**Consultation Response from Mark Berry KC,  
Highways Development Management**

**2023/92966 Land to the rear of, 271, Cliffe Lane, Gomersal, Cleckheaton, BD19 4SB**

**Demolition of existing dwelling and erection of 97 dwellings including formation of a new access from Cliffe Lane, landscaping, public open space and all associated infrastructure and engineering works**

**Date Responded: 5-2-2025.**

Drawing Number	152130-001	Rev	A
----------------	------------	-----	---

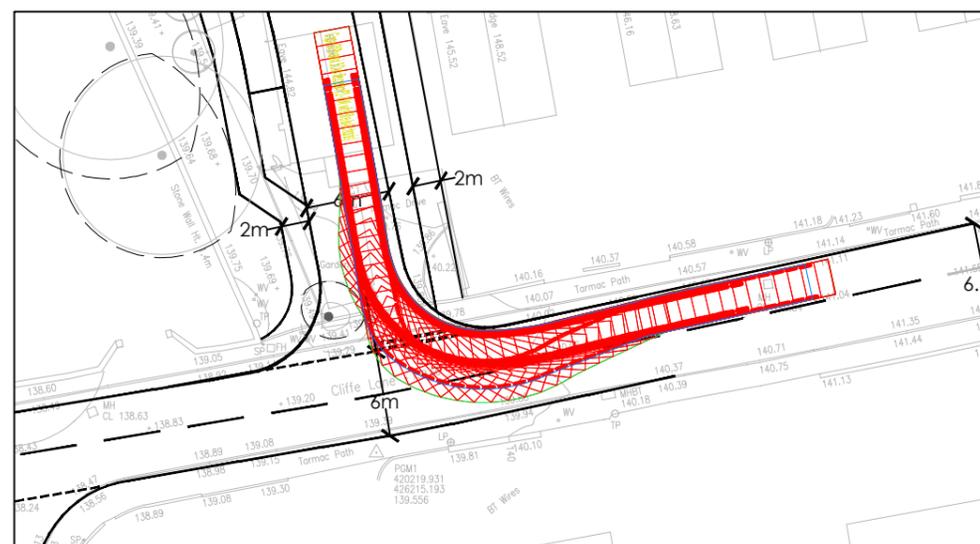
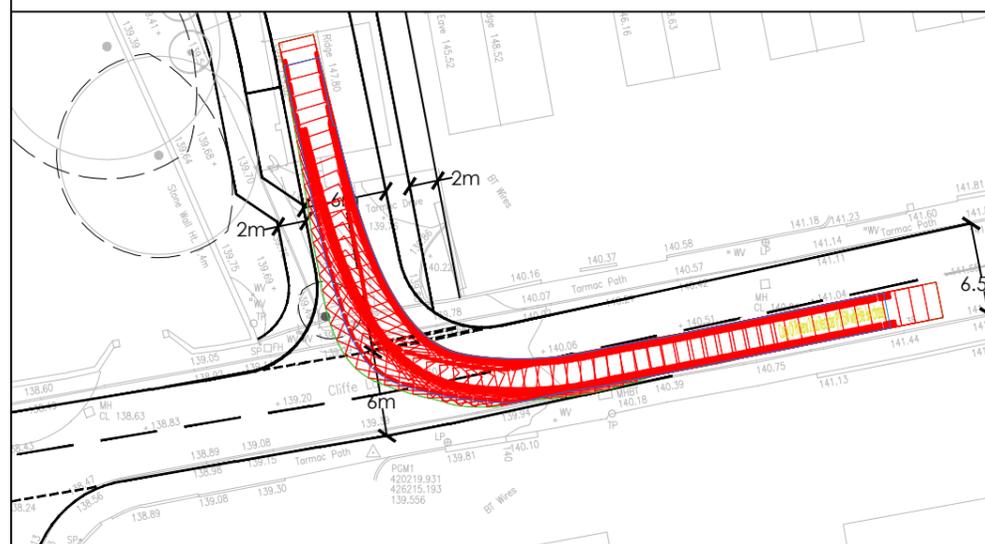
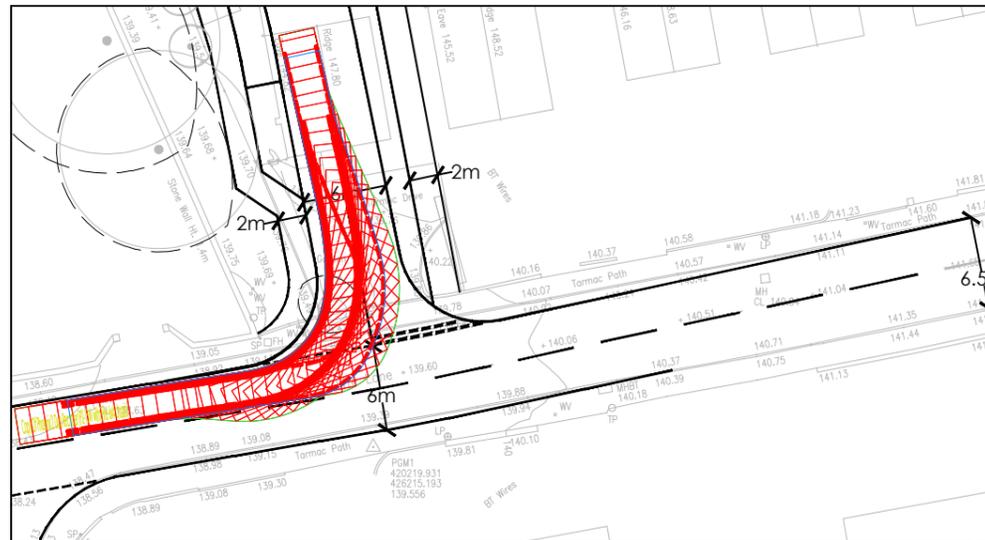
*The swept path for the shared surface will require amendment widening the carriageway in the area highlighted red in a blue circle below.*

ROAD 1 - LONGSECTION
SCALE: H 1:250, V 1:250. DATUM: 130.000

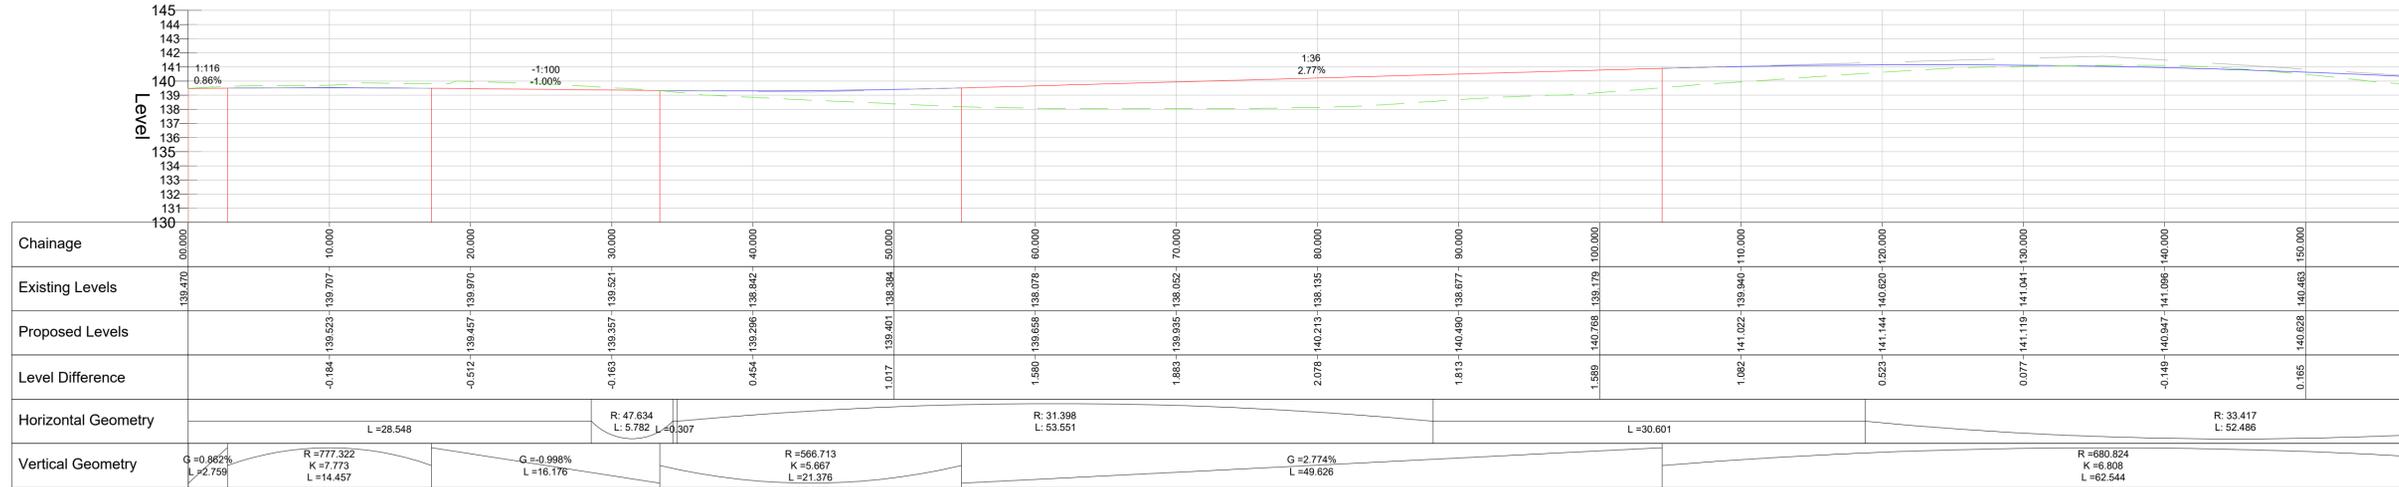
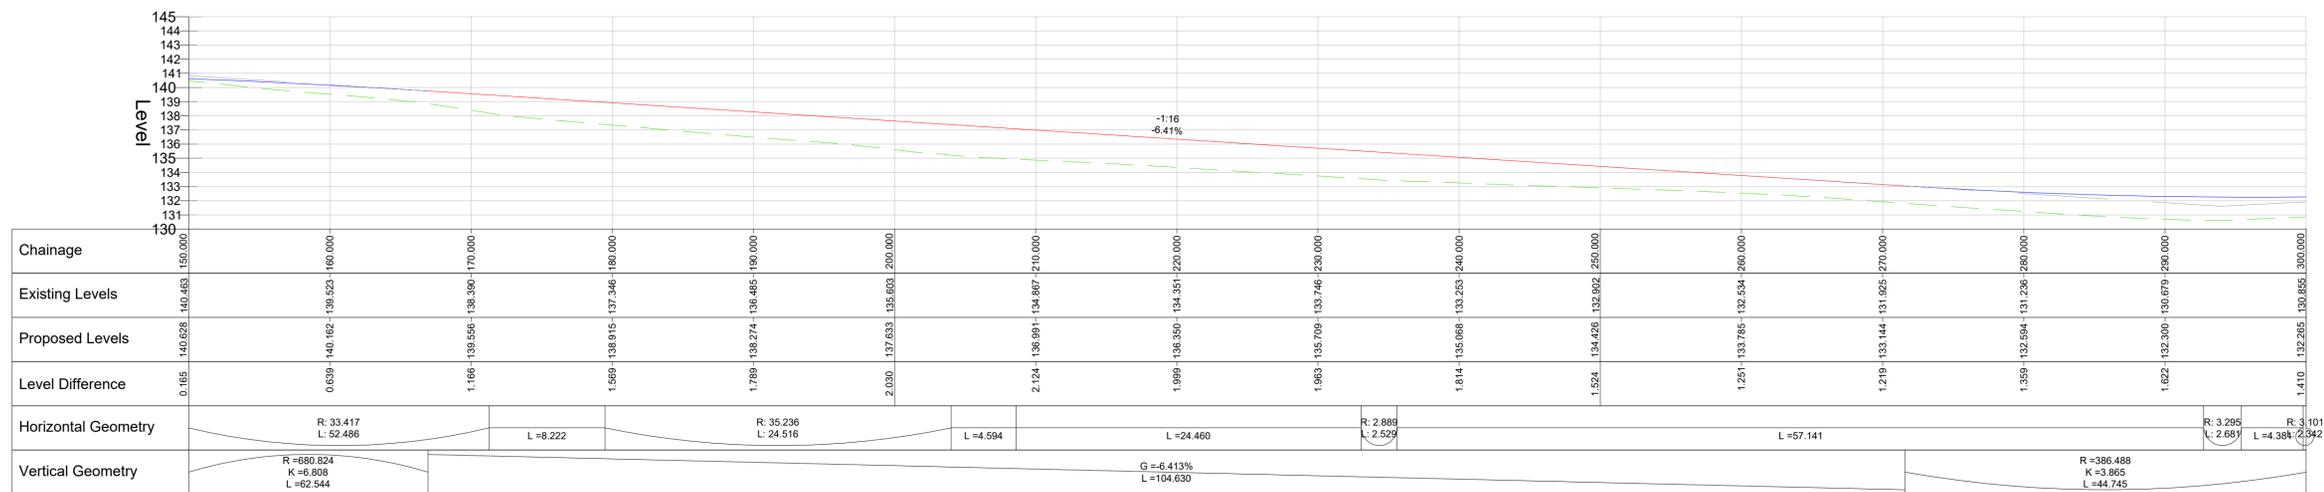
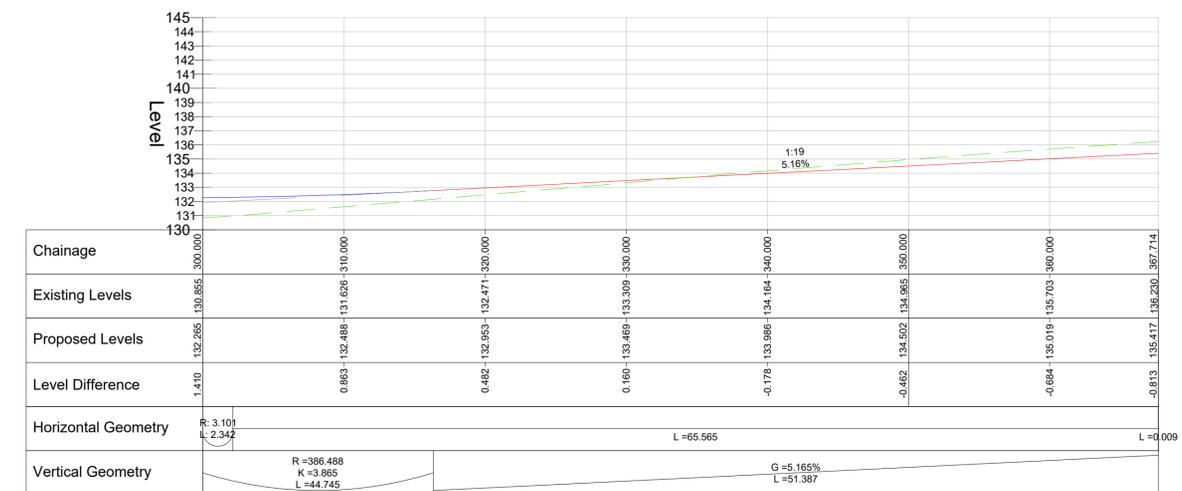
*"1, The plans show a footway to one side of the shared surface carriageway between chainages 170 to 270 where the gradients are greater than 5 percent (1 in 20). Footways should be shown to both sides. A 6.67 percent (1 in 15) gradient is shown to the shared surface between chainages 320 and 345m which is unacceptable.*

The revised plans now show acceptable gradients (1 in 20) to all section of the proposed shared surface carriageway such that footways are not needed to both sides. Footways are also now shown adjacent to the carriageways.
